RE: Bach Boundary Line Adjustment (BL-21-00023) Transmittal of Survey Comments

Parcel # 635436

Community Development Services (CDS) has received additional survey comments back from Public Works regarding your boundary line adjustment application. I have enclosed a copy of their comments for your review.

1 OF 2

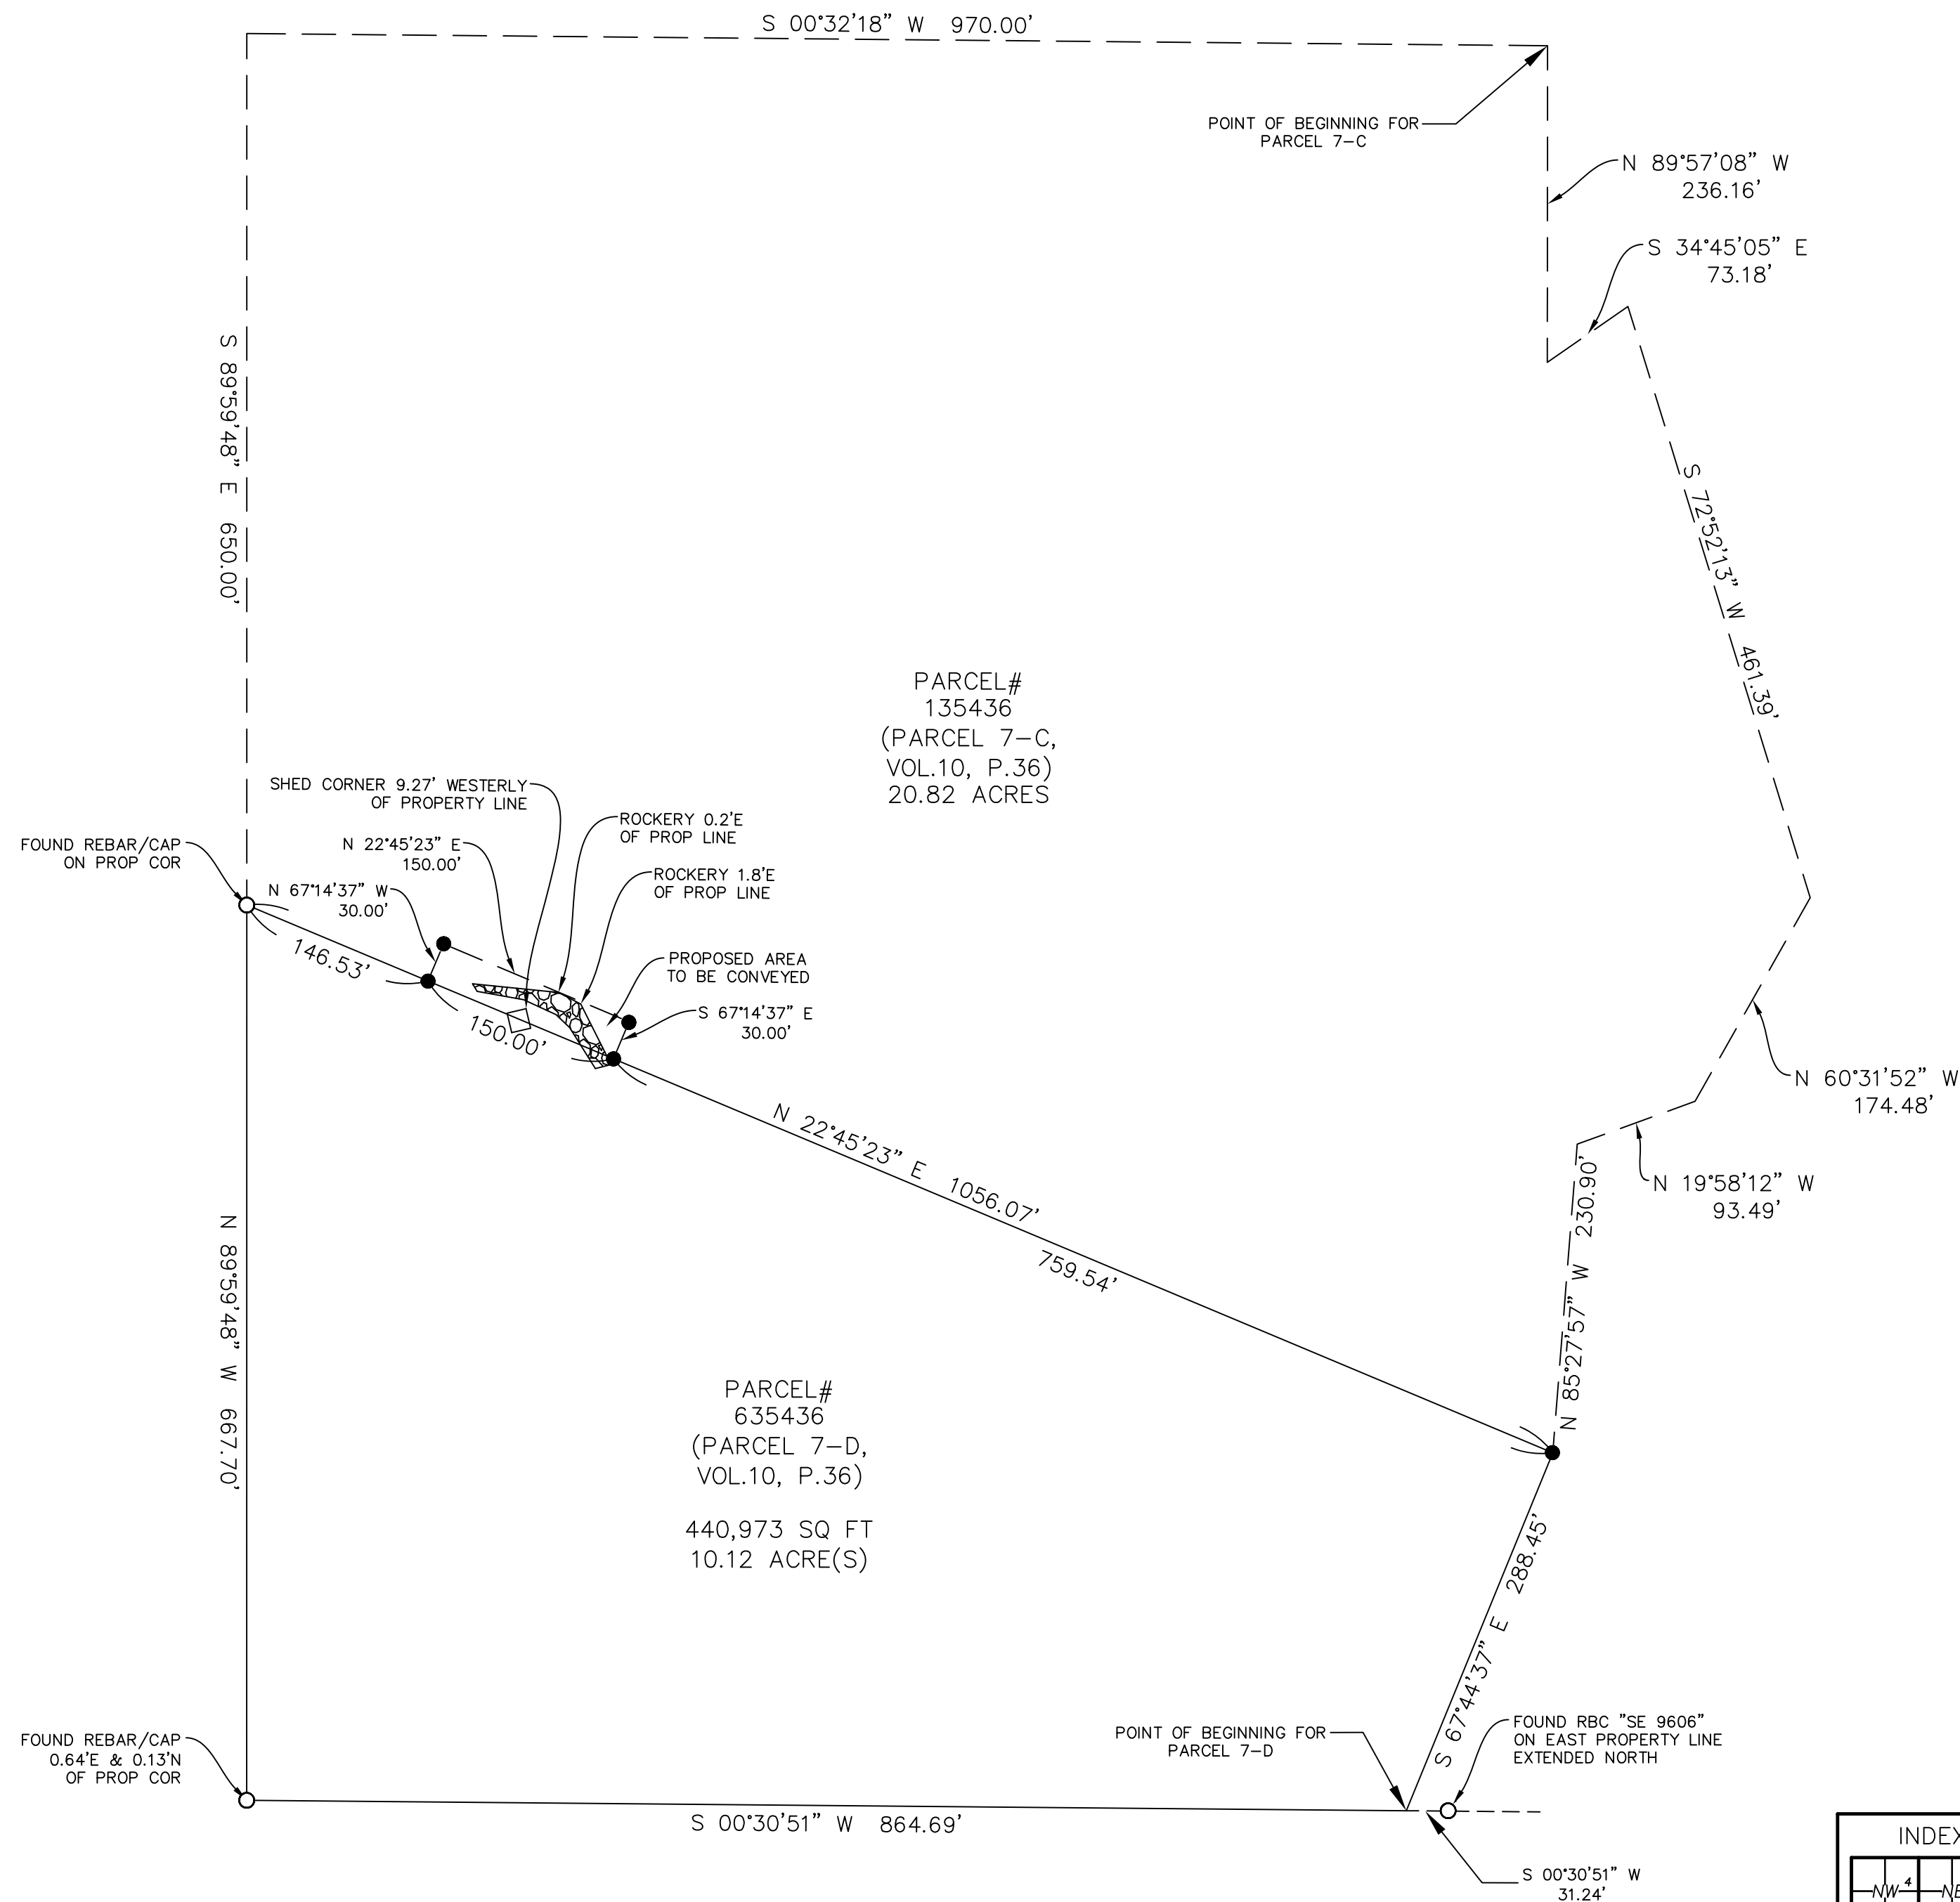
1. The entire new division line shall be staked in the field.
2. The proposed survey fails to adequately show controlling survey evidence. Please include ties to controlling corners suitable for sensible retracement of the boundary line adjustment.

3. The "Adjoiner" legal description does not match the text of the title report of record.
4. The legal descriptions are a mixture of basis of bearings. The original descriptions match the survey of record, while the transfer parcel matches the prepared map. Correcting the basis of bearing issues would resolve this, but alternatively, the record bearings could be provided on the face of the map in brackets "(XXX.XX)" and referenced on the legend.

5. The line "Thence S00°30'51"W, 864.69" within the Bach Legal description is missing from the title report. The title company can be informed, and generate an updated title OR, if they are unwilling to do so, the discrepancy can be noted and the source of the missing data (Survey:10-36) provided.
